**Consultation Response from KC,
Lead Local Flood Authority****2024/93594 Hollinghurst Farm, 76, Hall Ing Lane, Honley, Holmfirth, HD9 6QR****Erection of 9 dwellings including associated works****Date Responded: 21/03/2025.****Responding Officer: Martin Stephenson****Responding Ref: 1****Documents reviewed by the LLFA:**

Beam Consulting:

- 186-62-500, Outline Drainage Strategy, Rev – dated 19/12/2024.
- 186-62-DOC001, Flood Risk Assessment, Rev – dated 19/12/2024

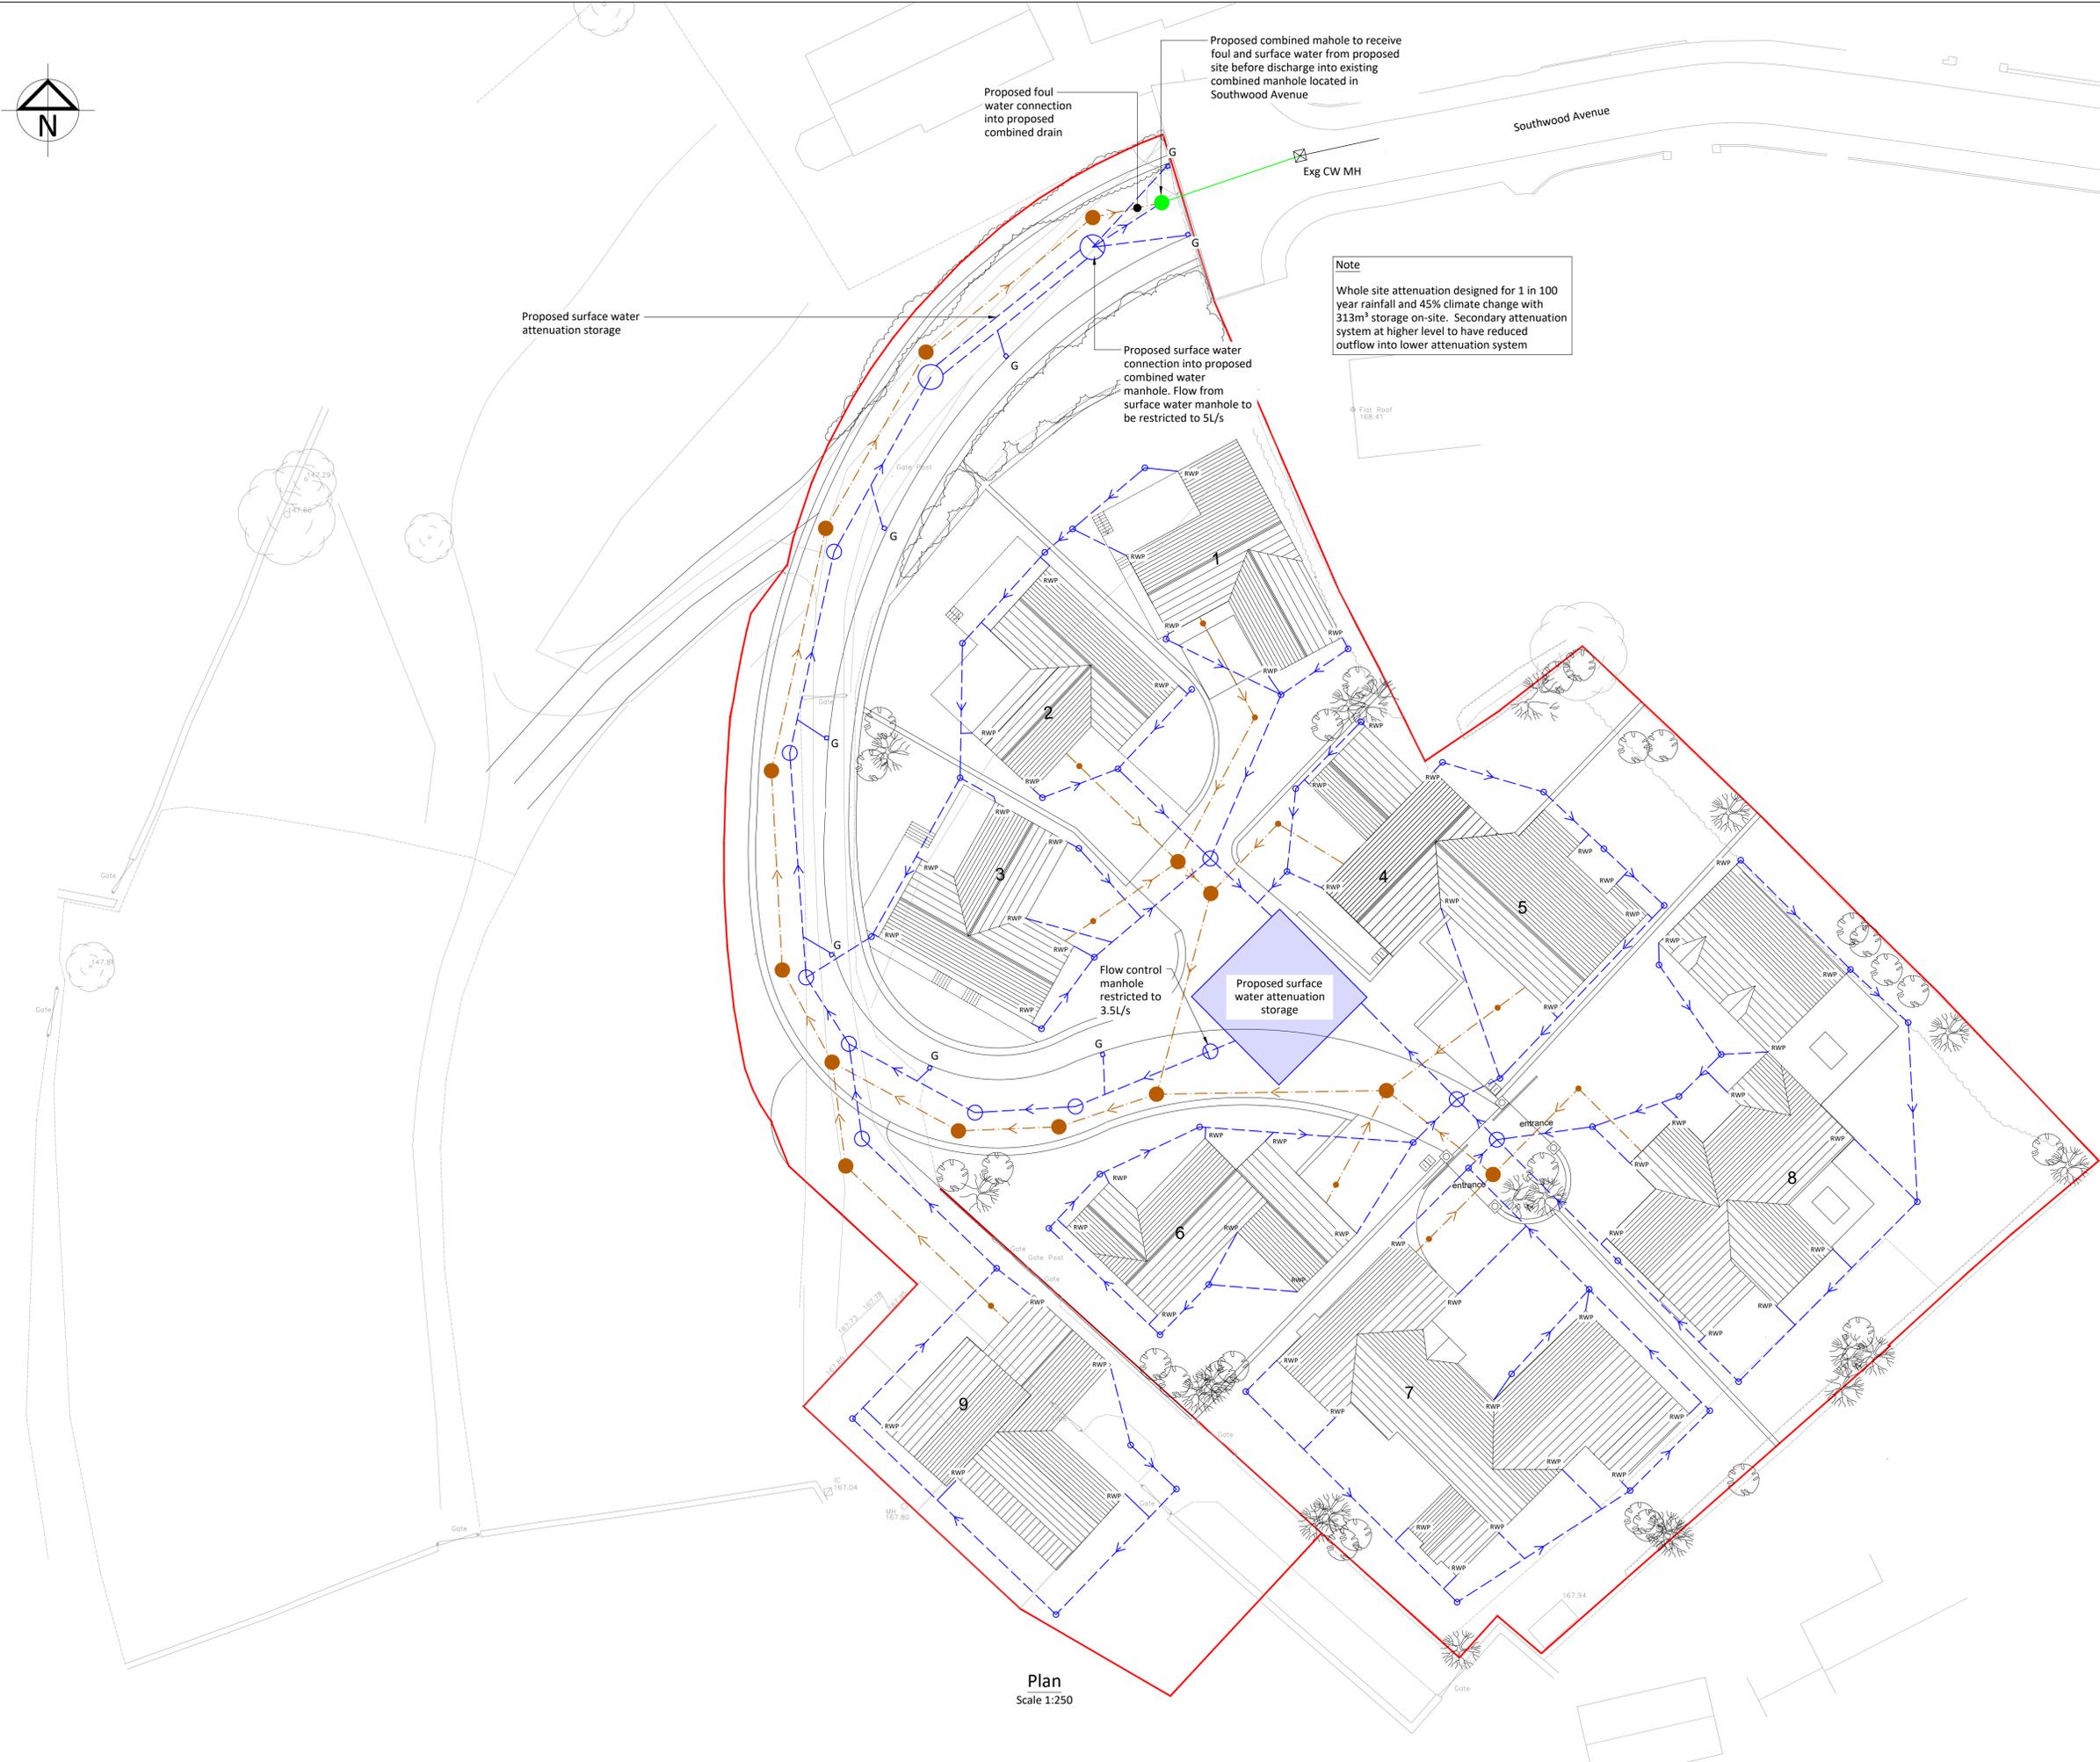
The LLFA accepts that infiltration into the ground is not viable for surface water disposal due to a BGS score of 4 and the steepness of the slope in the vicinity of the site and the risk of re-emergence further downhill.

Further, the LLFA accepts that discharge of surface water to the public combined sewer is acceptable (subject to agreement with Yorkshire Water).

For a site area of 0.77ha and a GFRO rate of 5.0 l/s/ha, the allowable discharge rate would be 3.9l/s, however it is noted in the FRA that a 5.0l/s is proposed. The LLFA would expect the final discharge of surface water to be **3.9l/s** (subject to a minimum flow control outlet diameter of 75mm).

Hydraulic calculations at the above allowable discharge rate will need to be provided to the LLFA indicating the required surface water attenuation storage for the critical 1 in 100 (plus climate change) rainfall event without off-site discharge or flooding to existing and proposed dwellings.
